CITY OF ALBUQUERQUE

**Re: Dutch Bros
700 Coors Blvd NW
30-Day Temporary Certificate of Occupancy
Transportation Development Final Inspection
Engineer's/Architect's Stamp dated 5-1-20 (J11D039)
Certification dated 11-20-20**

Drawing No. **C8.0**

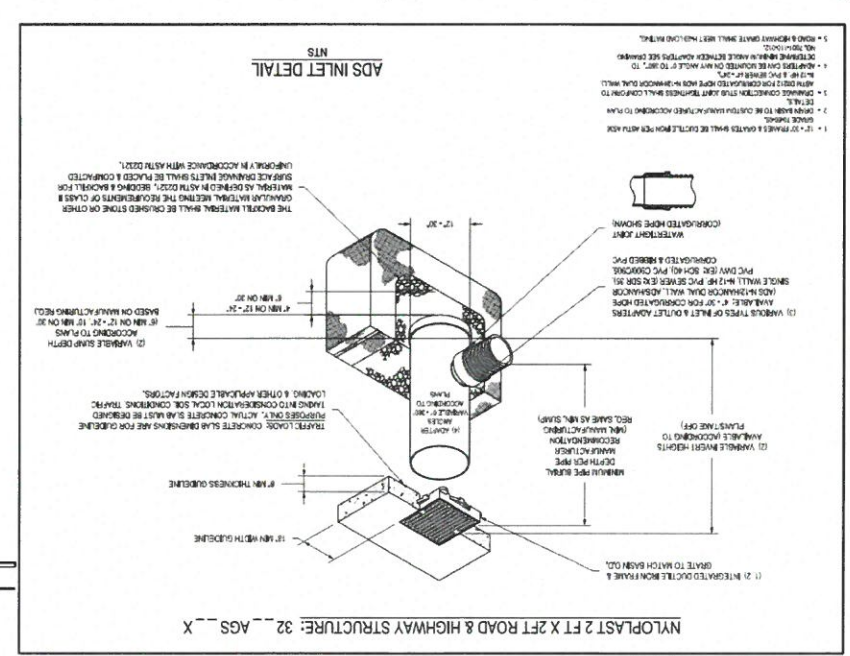
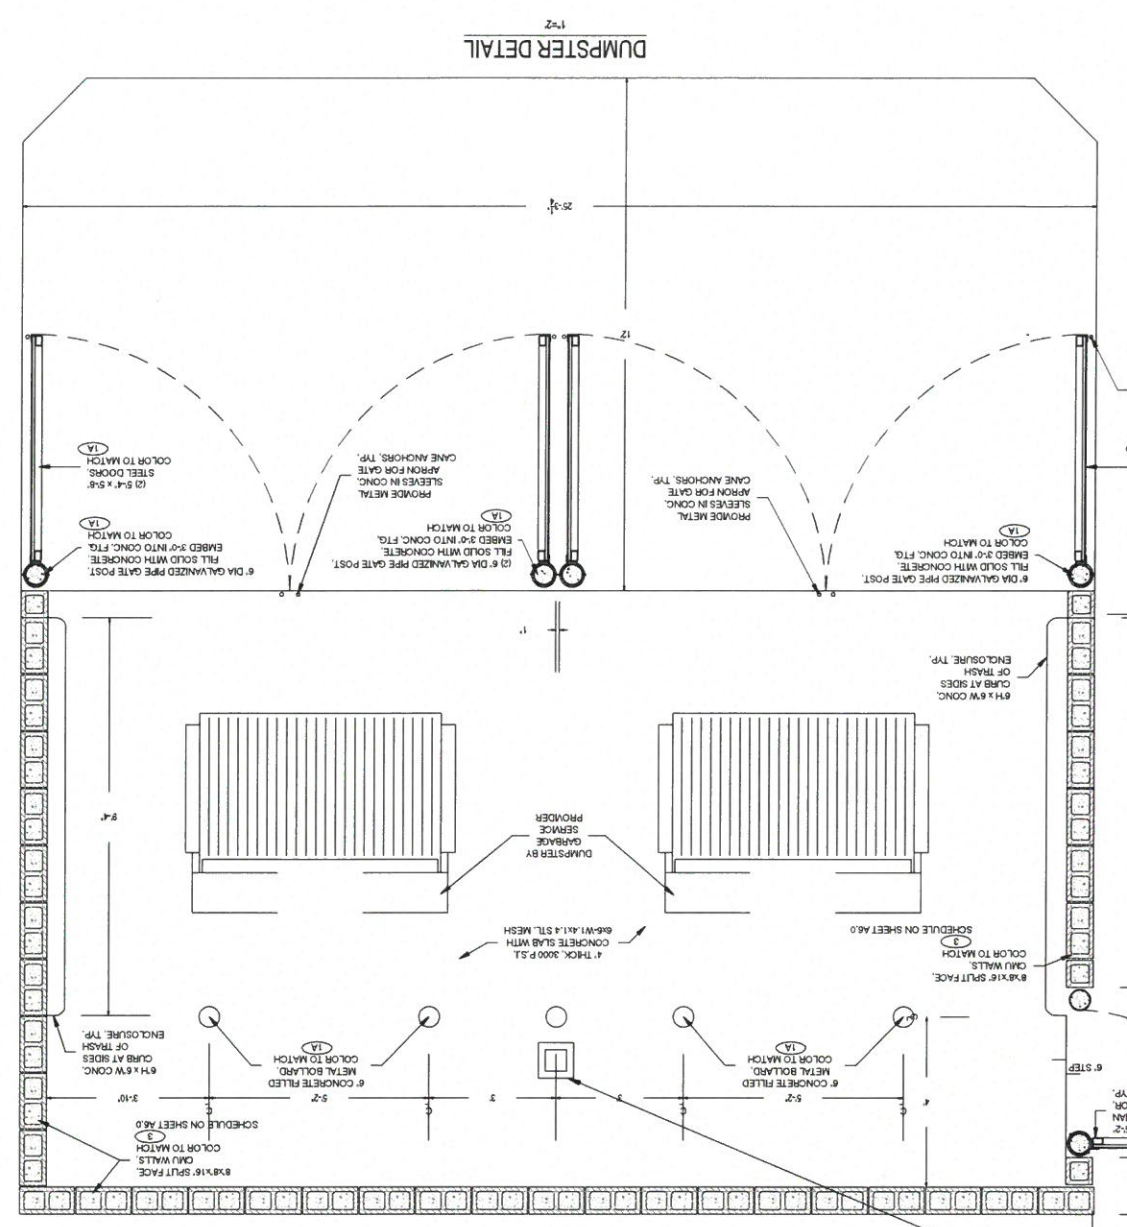
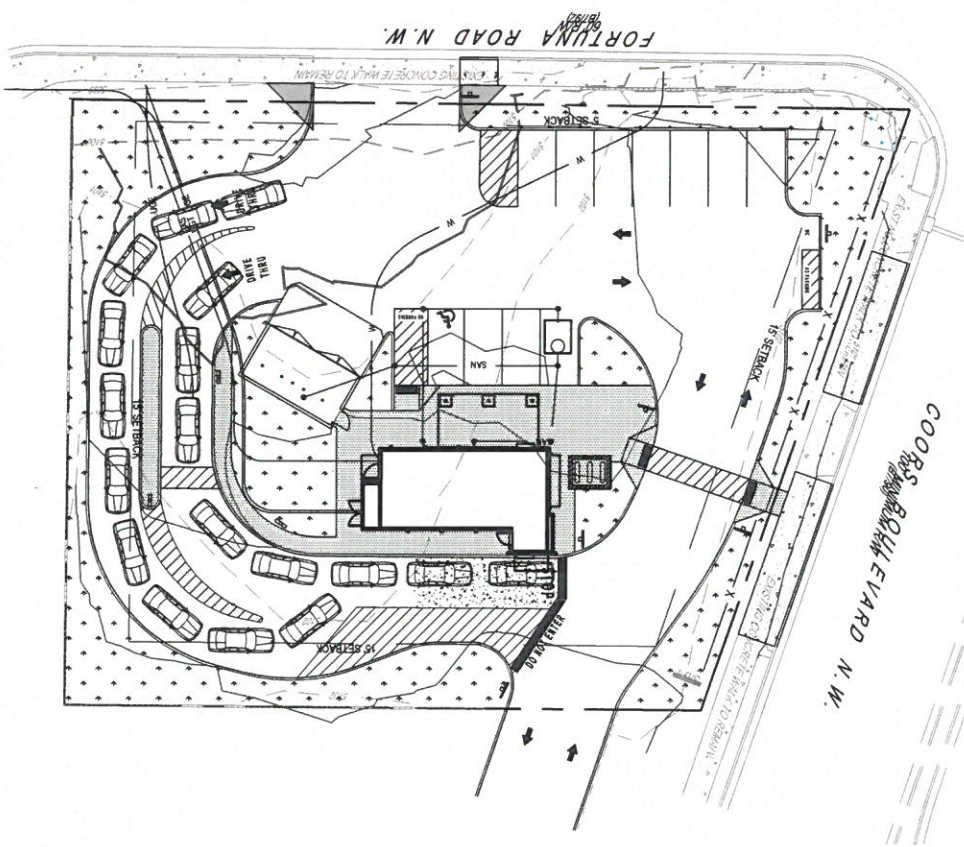
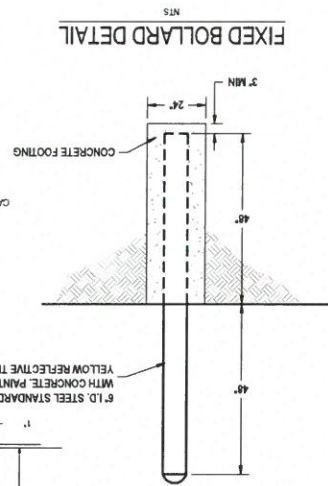
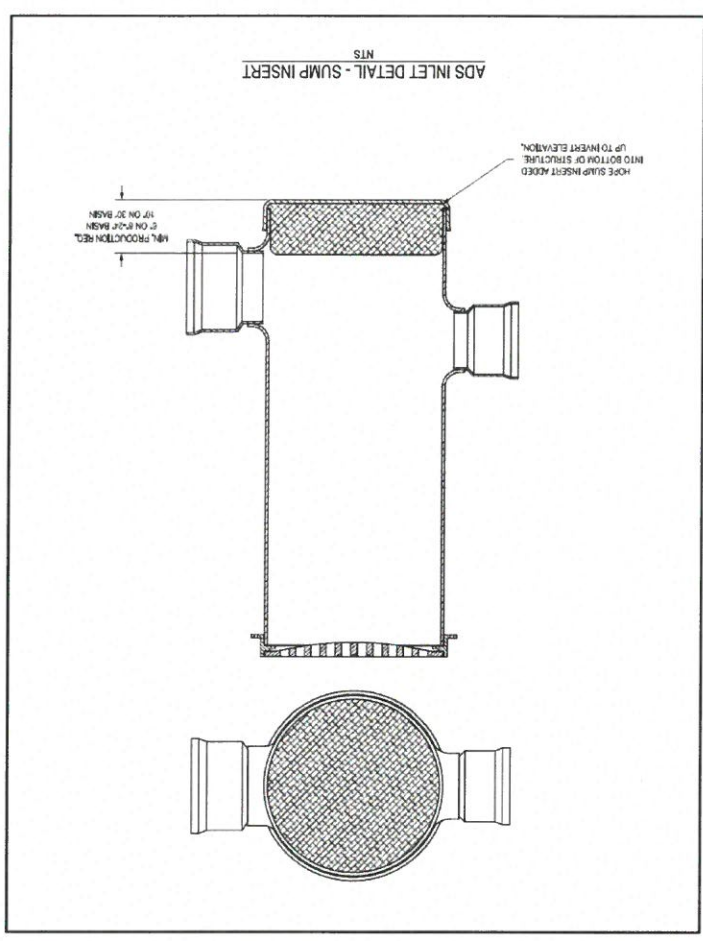
- Please add Motorcycle signage.
- Please stripe and add No Parking to key way located next to MC parking.
- Please complete construction of shared access.
- Remove construction debris, equipment, trash container and porta potty.
